RF WINDOW SILL DETAIL M1
1-1/2"=1'-0"

MAINE MEDICAL CENTER
BRAMHALL CAMPUS
MRI #1 REPLACEMENT
PORTLAND, MAINE
ELEVATIONS, SECTIONS, AND
DETAILS

PROJECT MANAGER: DJV	PROJECT NO: 16004
AVE OF RECORD: DJV	
JOB CAPTAIN: MDR	
DRAWN BY: MDR	
SMRT FILE: AE103-16004	SHEET No. AE103

CONTROL ROOM A7
1/4"=1'-0"

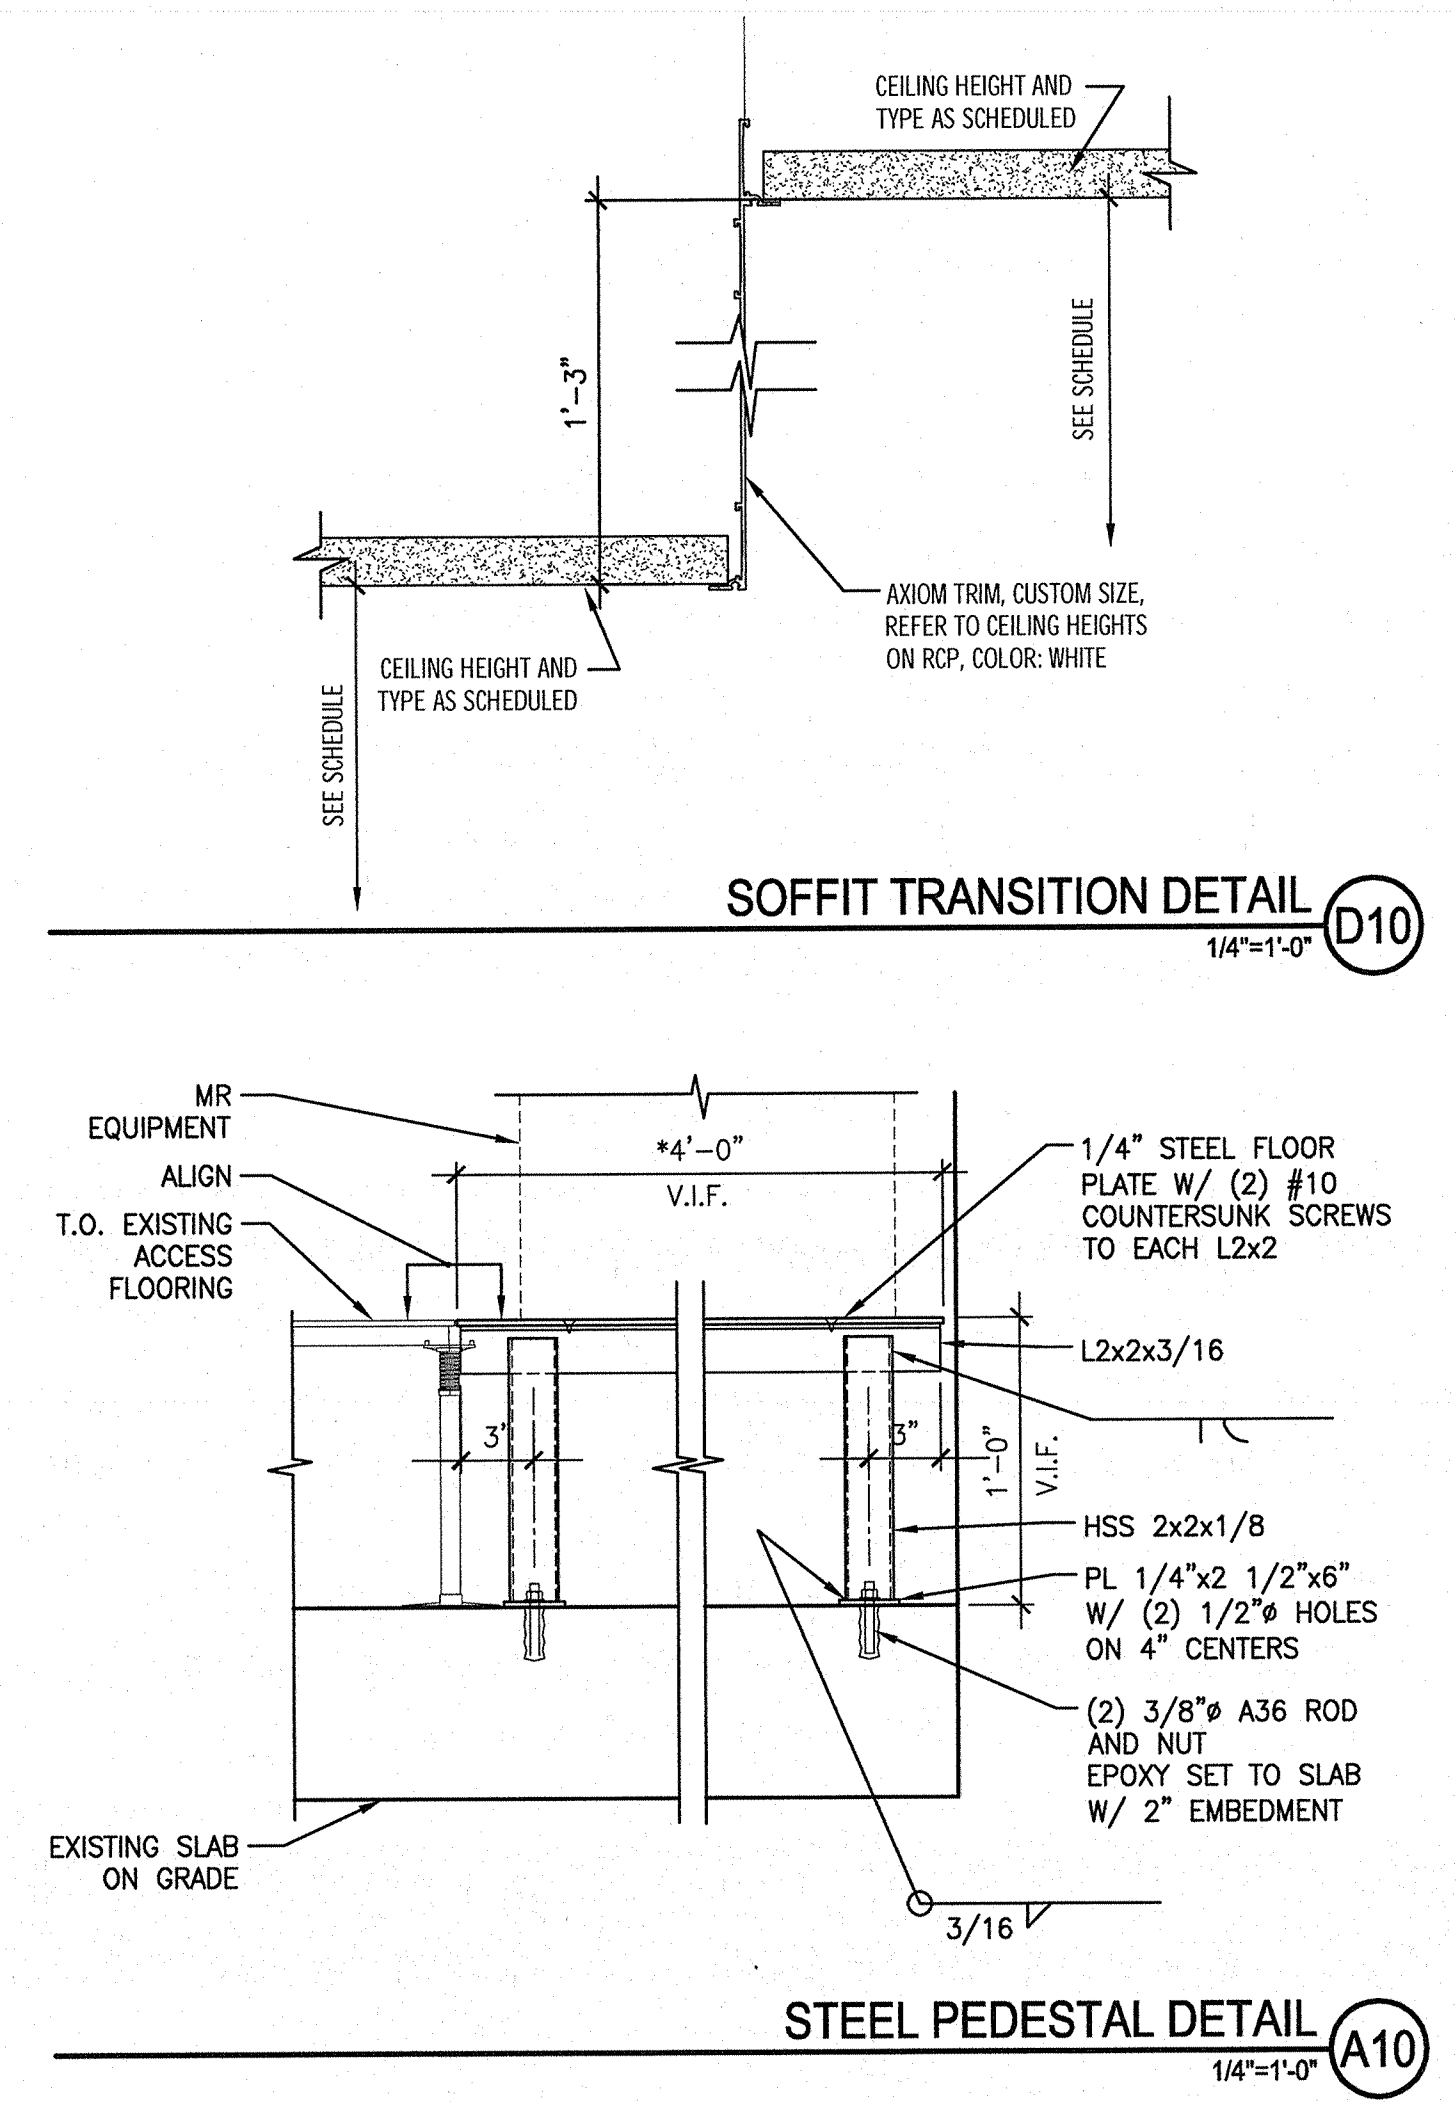
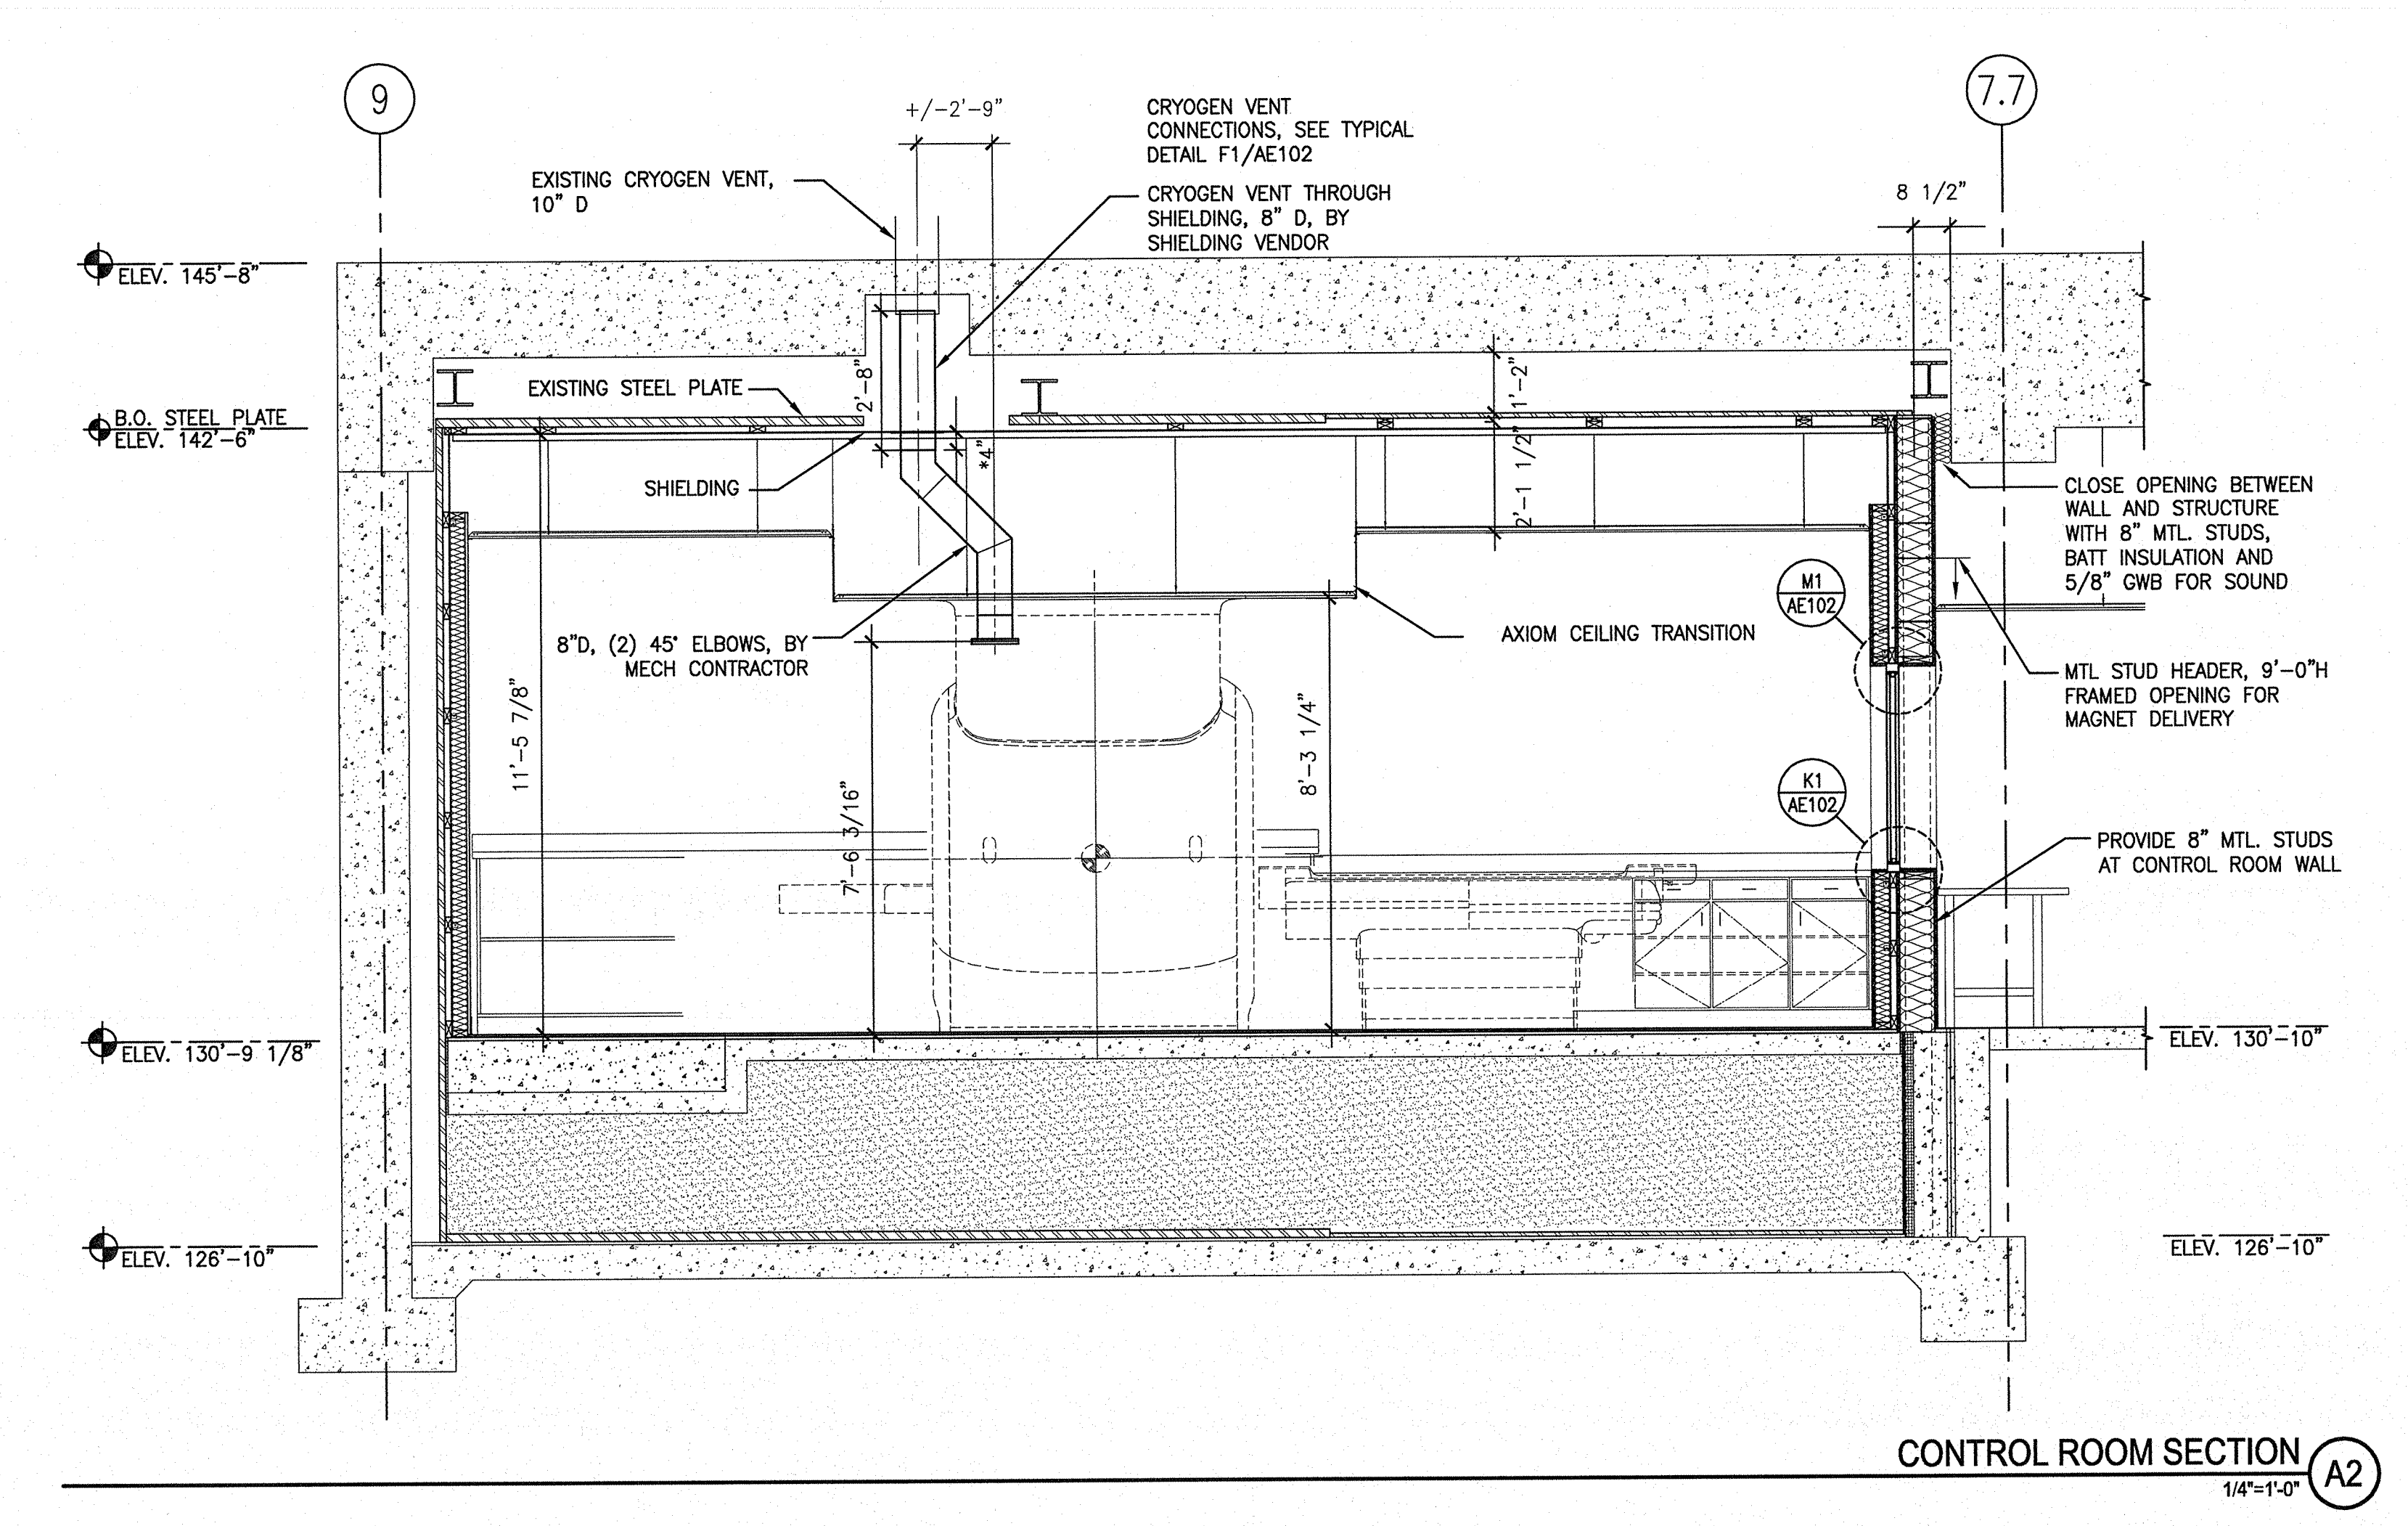
Does the new machine weigh more or less than the old?

This is magnet #2 penetration panel, not in scope of project

This is dirt below the existing slab...this is an existing condition.

Existing steel plate, once use as magnet shielding, existing condition to remain

What does this represent?

GE 3t machine (to be removed): 17,312 lbs
Philips 1.5t (to be installed): 9921 lbs
